Central Carolina Soil Consulting, PLLC

Job # 3806

RE: Site meeting at lot 31, Honeycutt Hills SD, Harnett County, NC.

SITE SKETCH

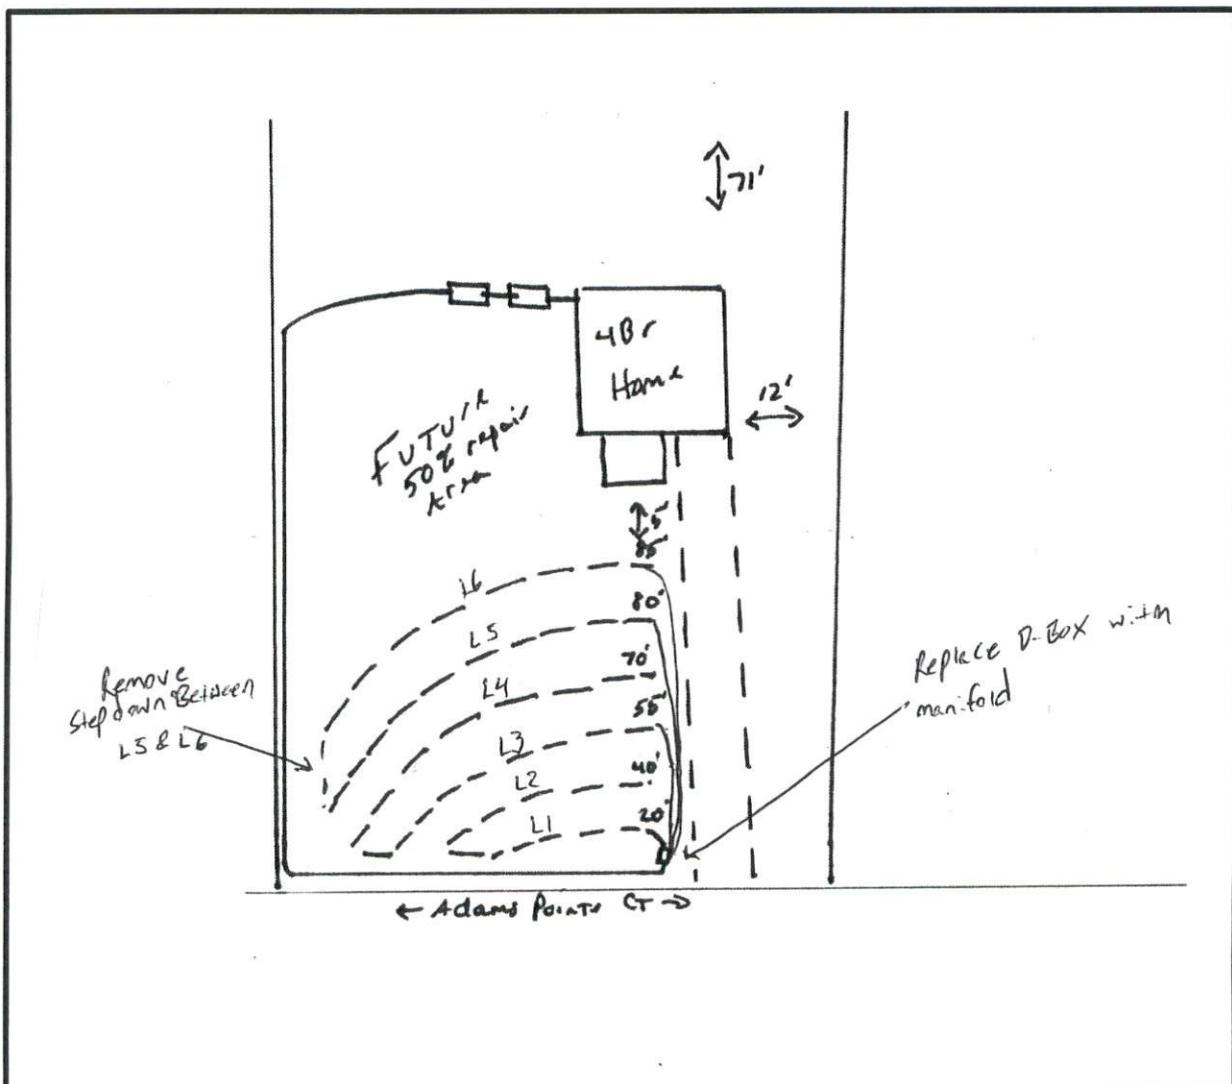
Central Carolina Soil recommends to install a manifold box with taps (see tap chart) to feed some of the lines individually to better disperse the effluent (with the exception of lines 1-2 (20' & 40') & 3-4 (55' & 70') keep those step-downs). Additionally, the current control panel shall be replaced with an Aquaworx control panel to control the dosing of the system. The flow shall be split between 4 cycles per day (every 4 hours) away from a larger demand dose system. Water records need to be taken on the lot to ensure the system is not being over loaded based on the daily flow rate.

Keep existing step-down between lines 1-2 and lines 3&4.
